LPA Ref: ^{FN/36/11/}
~~FP/193/11/~~

Proposal: Regeneration of Dilapidated Stableyard and Associated Buildings, comprising 1 No. Holiday Cottage, 2 No. New Dwellings (together with Replacement Dwelling, Ancillary Stables and Storage Barn as previously permitted under FN/437/09) to include Revised Vehicular access arrangements to provide separate access for Stables - amendment to Refusal FN/83/10 (this Application is a Departure from the Development Plan and lies within the South Downs National Park Authority)

Address: Soldiers Field, Soldiers Field Lane, Findon.

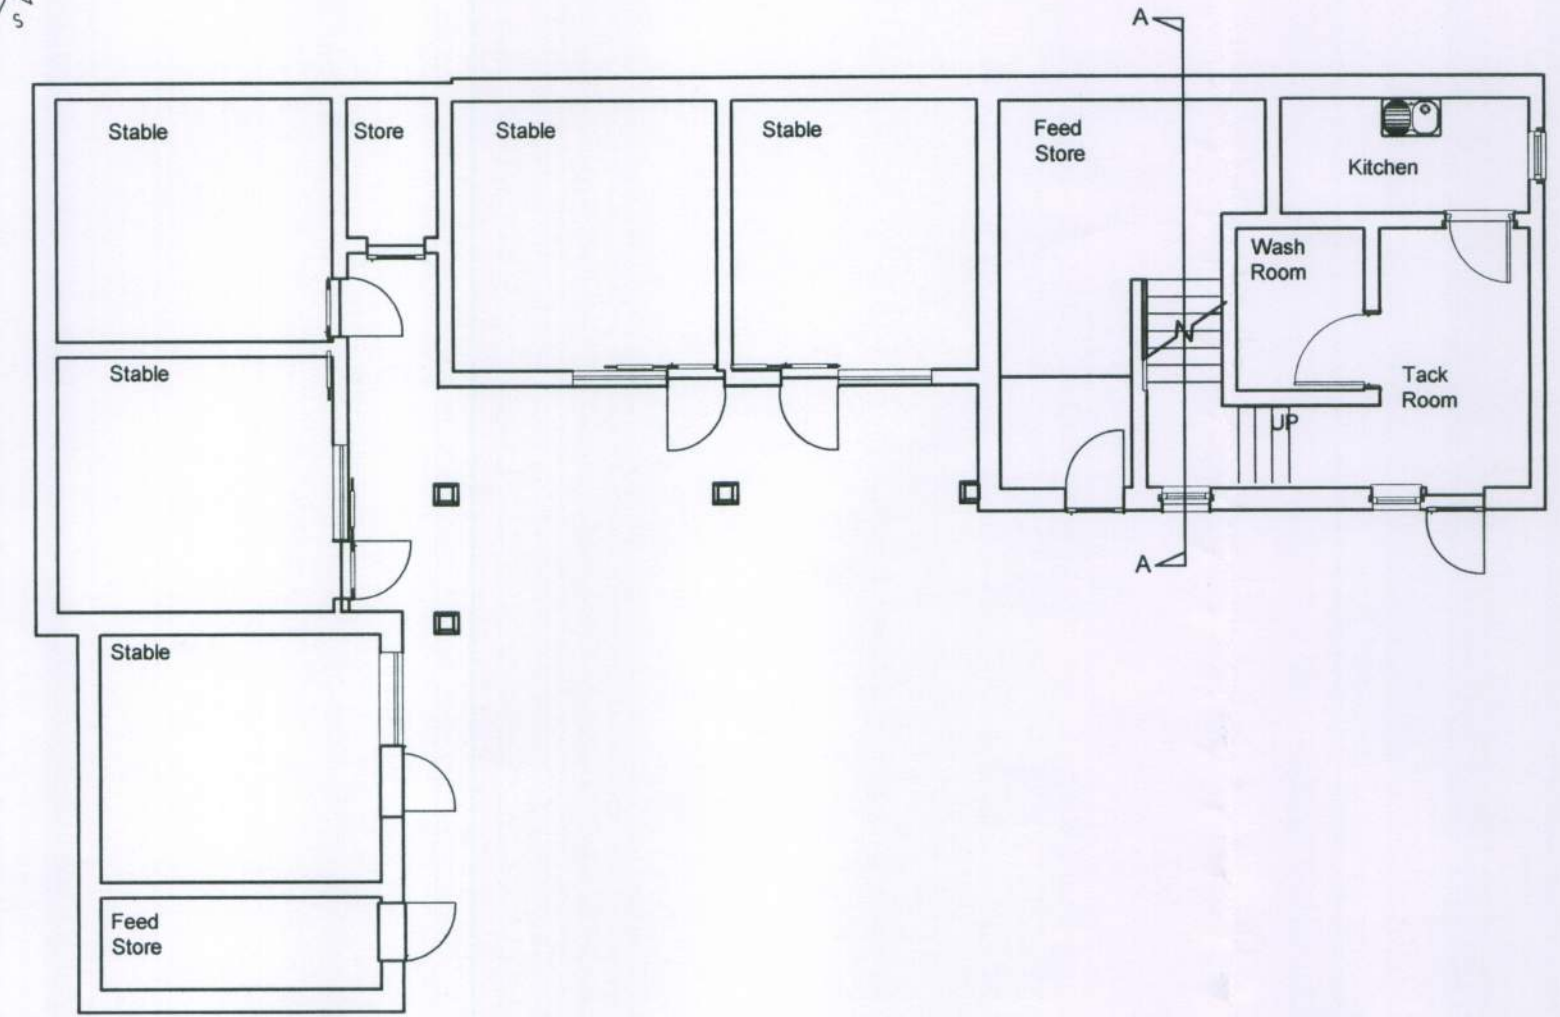
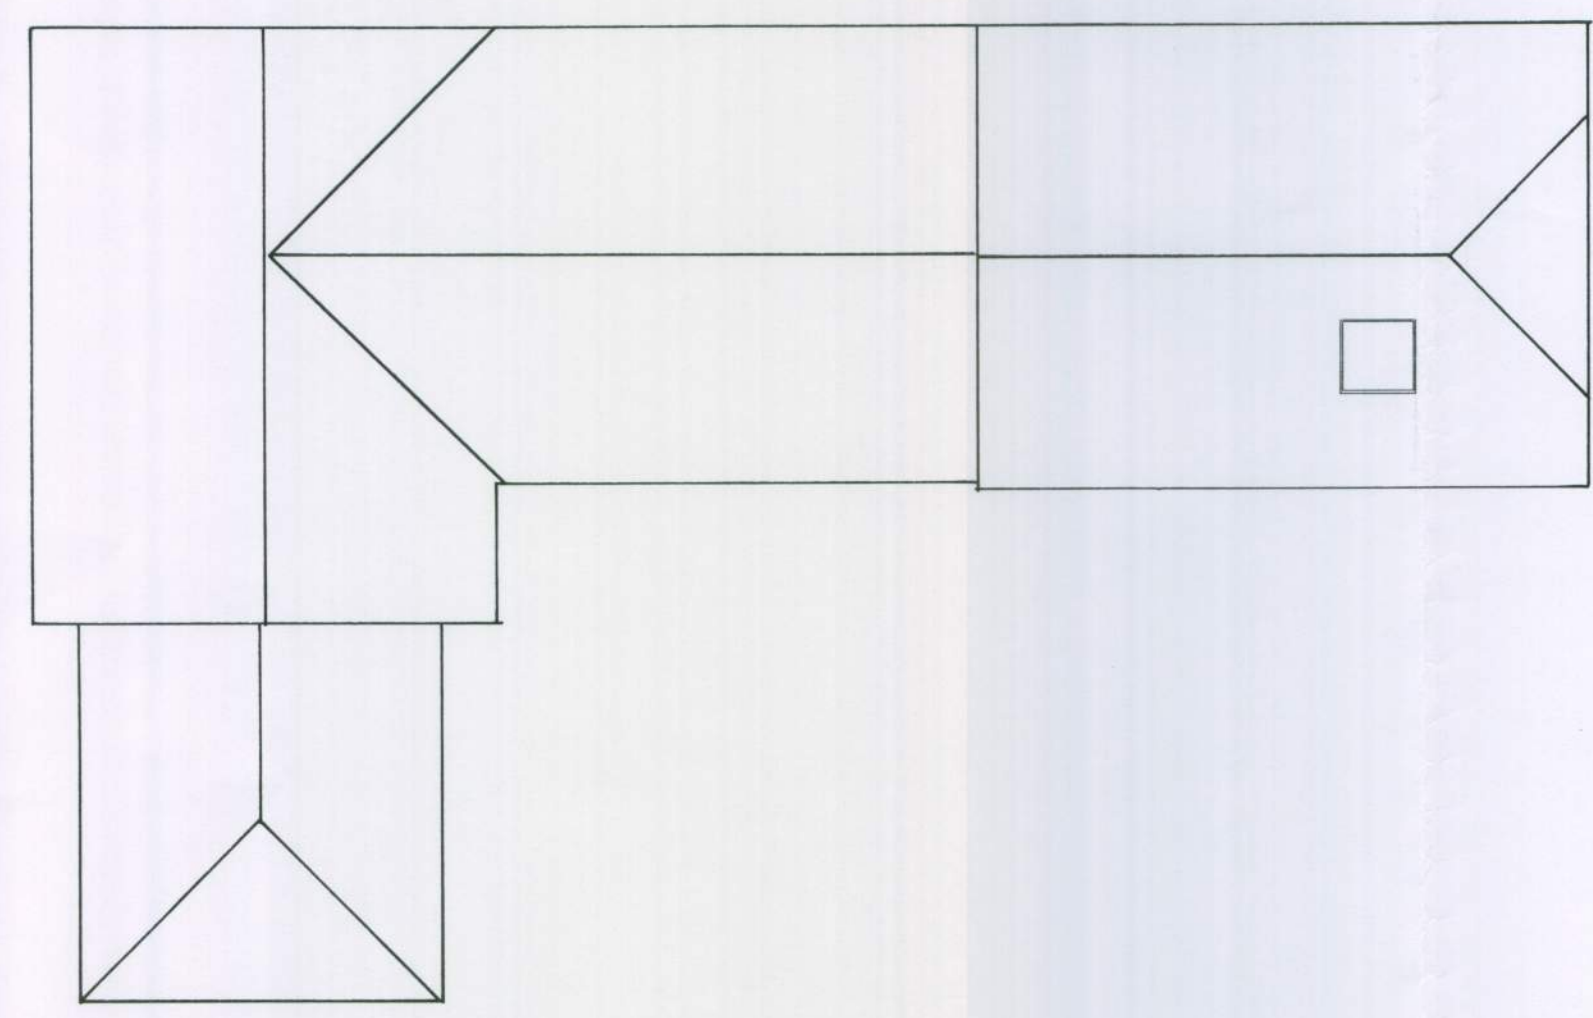
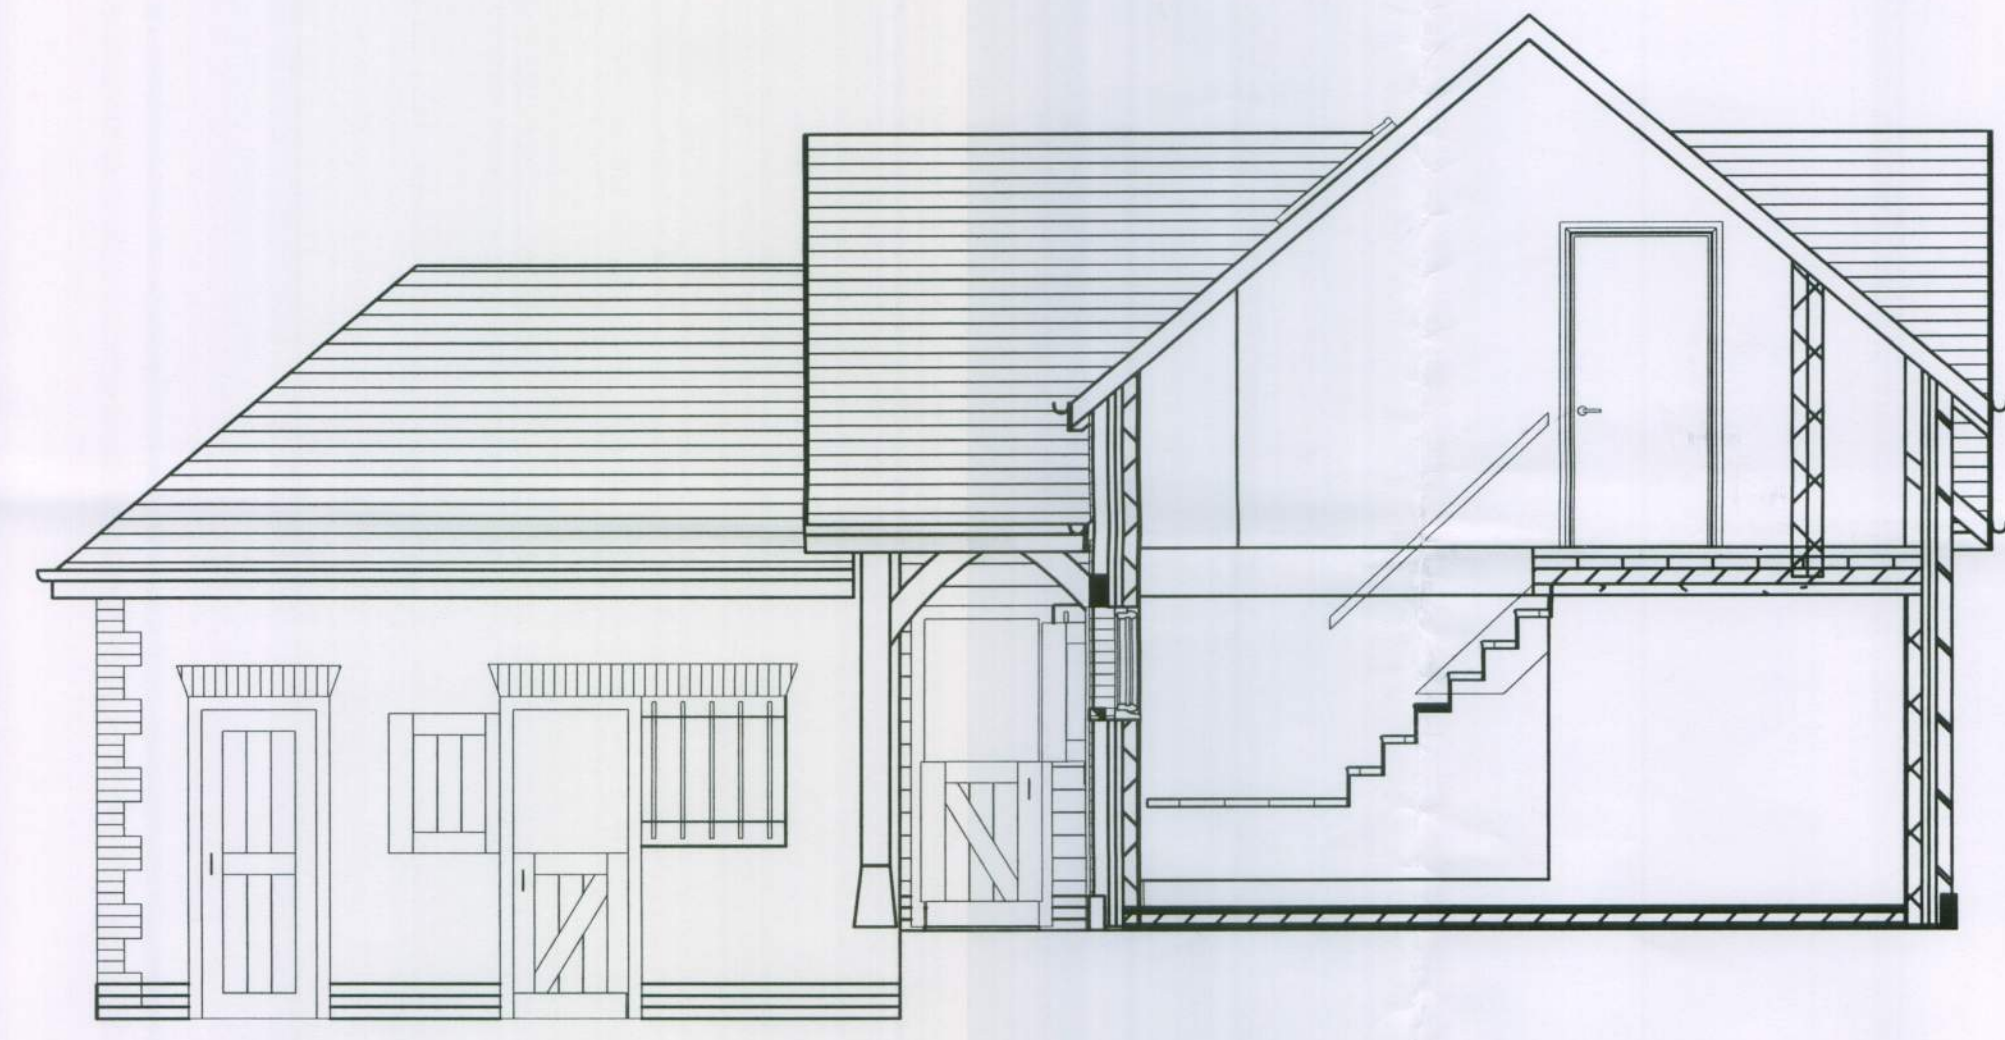
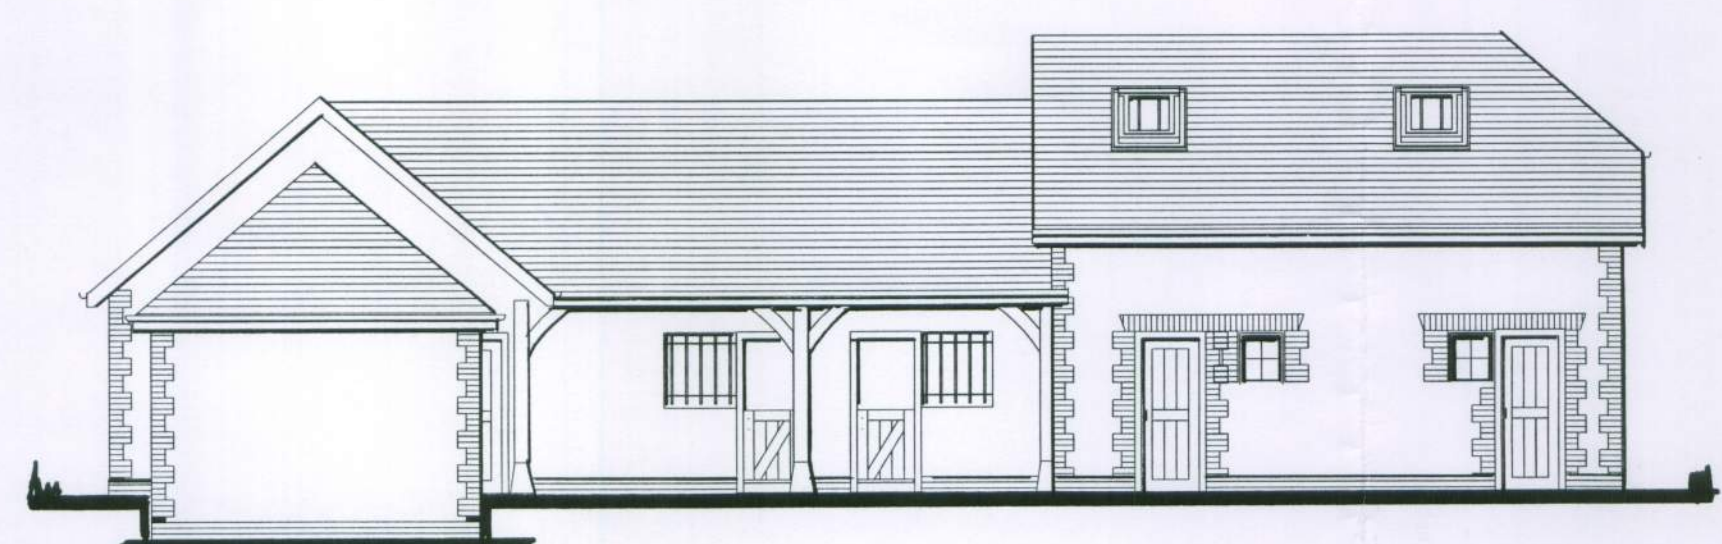
I refer to the above application and note that drawing nos 10/157/p03, 10/157/p05, 10/157/p07, 10/157/p06A, 10/157/p04 and 10/157/p02 contain a note saying 'Do not scale from the drawing'. This is not acceptable as part of the submission of a planning application and I request that you confirm in writing that I can either delete this reference or amend it by adding 'except for planning purposes'.
